PROJECT NAME | House extension at 30 The Parkway, Rustington, BN16 2BU, UK
DRAWING TITLE | Planning Application Drawing - Existing Roof Plan

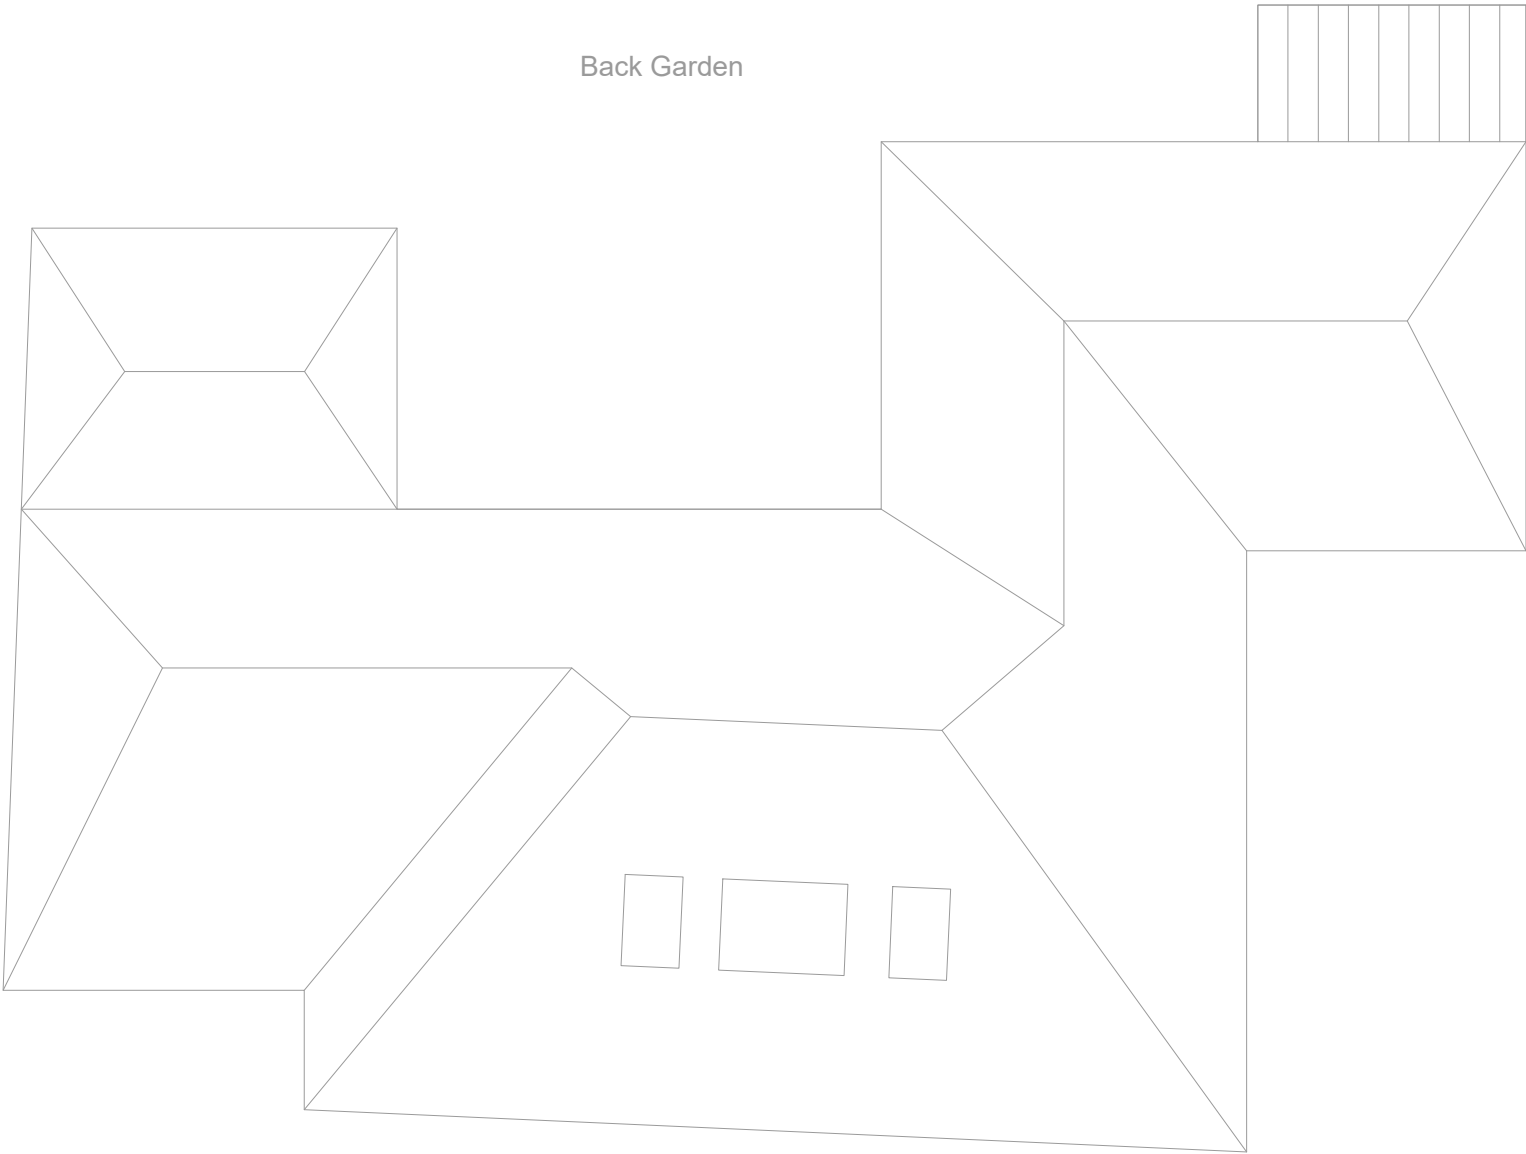
However, this application is still invalid as the proposed roof plan is labelled existing. Along with this, as you have answered no to question 2a on the CIL form, this means you must answer question 3 and continue from there. Please review and amend.

Plan Produced for: Planning Permission

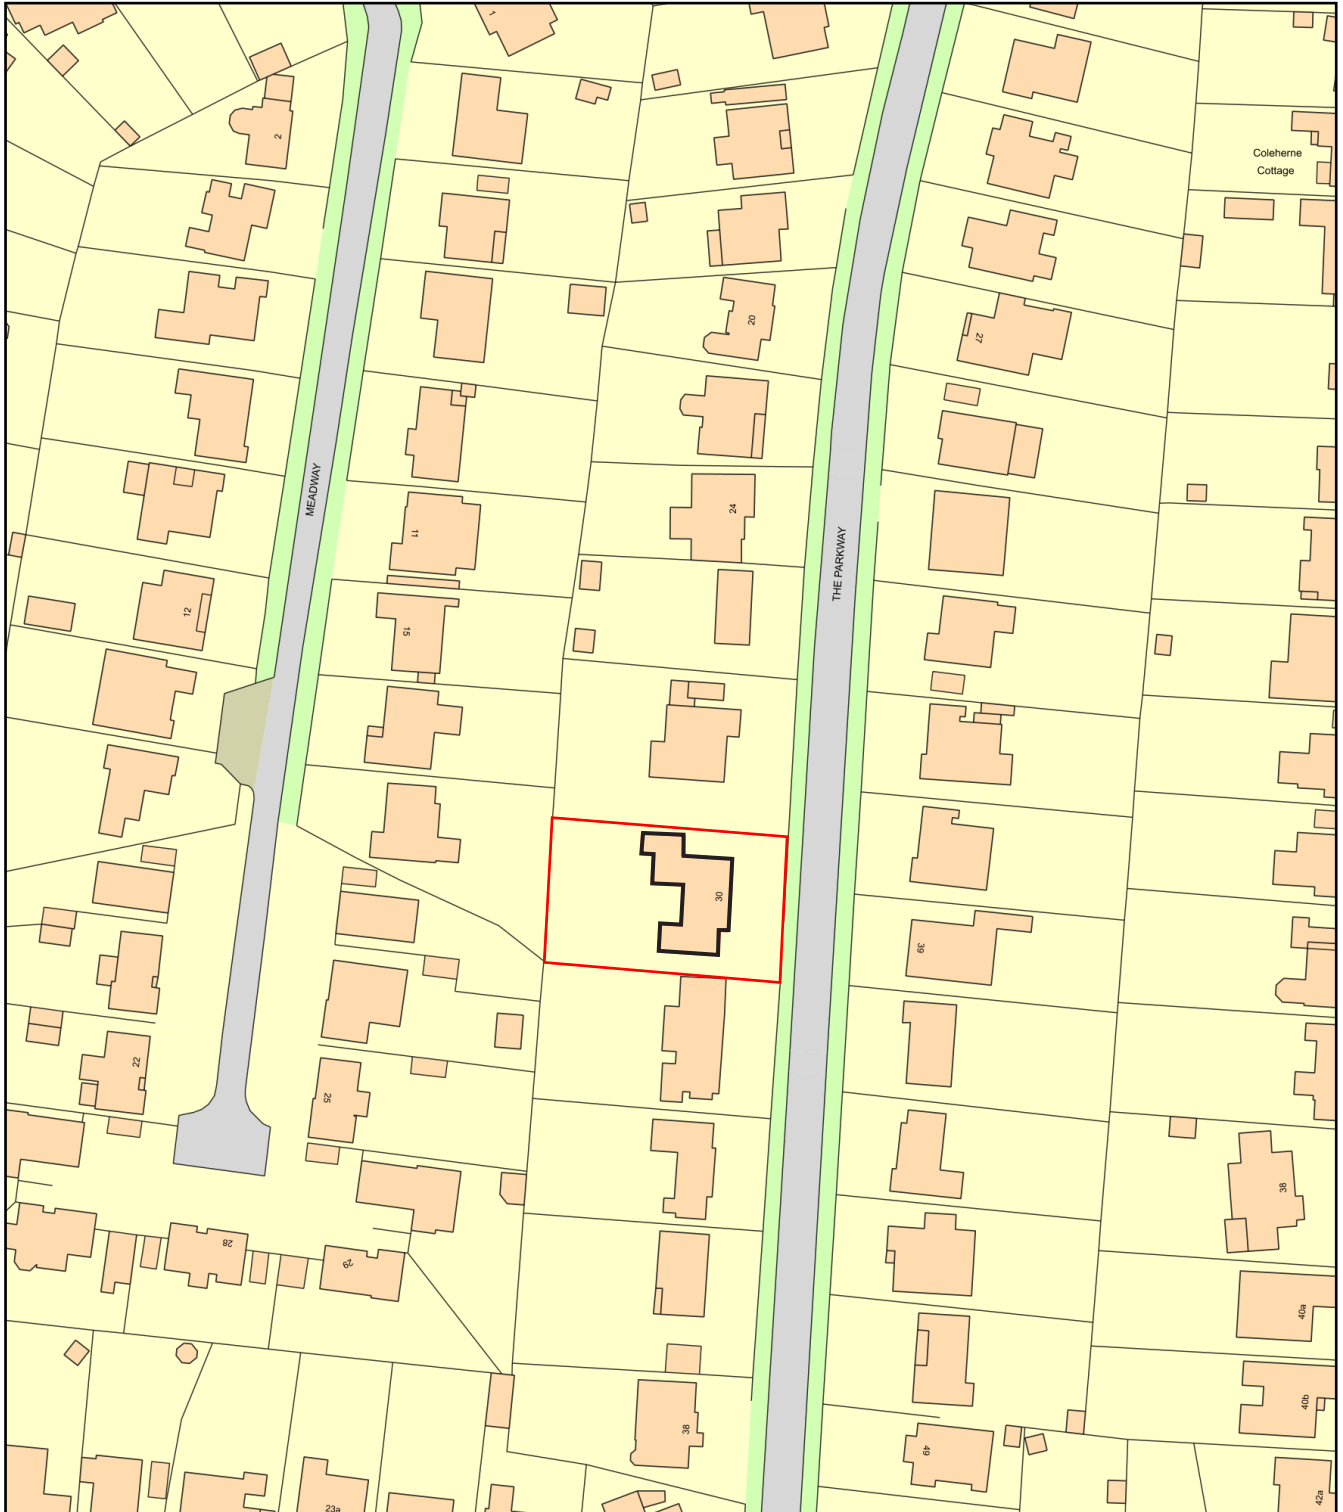
Location Plan: The red outline needs to be around the entire site boundary rather than just the property. Please amend.

PROJECT NAME | House extension at 30 The Parkway, Rustington, BN16 2BU, UK
DRAWING TITLE | Planning Application Drawing - Proposed Block Plan 1/500

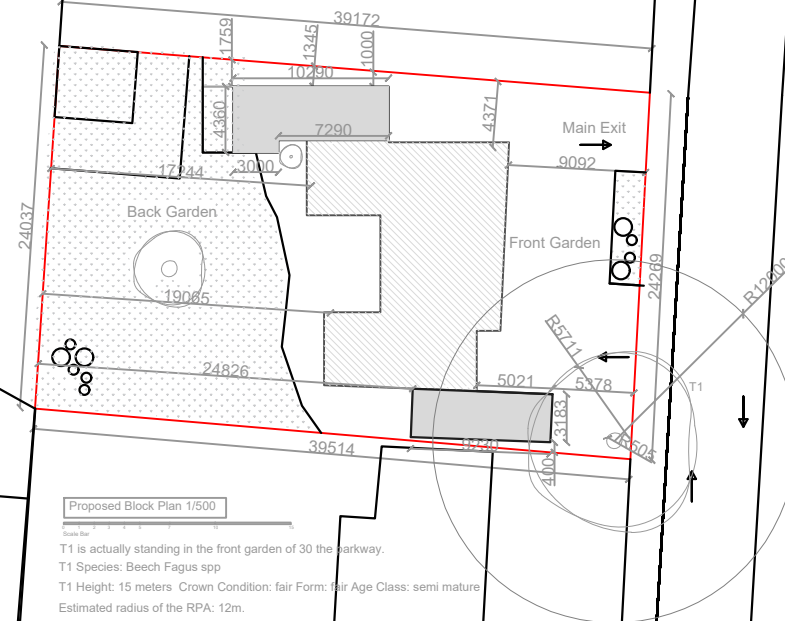
Block Plan: Please submit a proposed block plan scaled 1:200 or 1:500 with dimensions from the proposed side extension to all site boundaries.
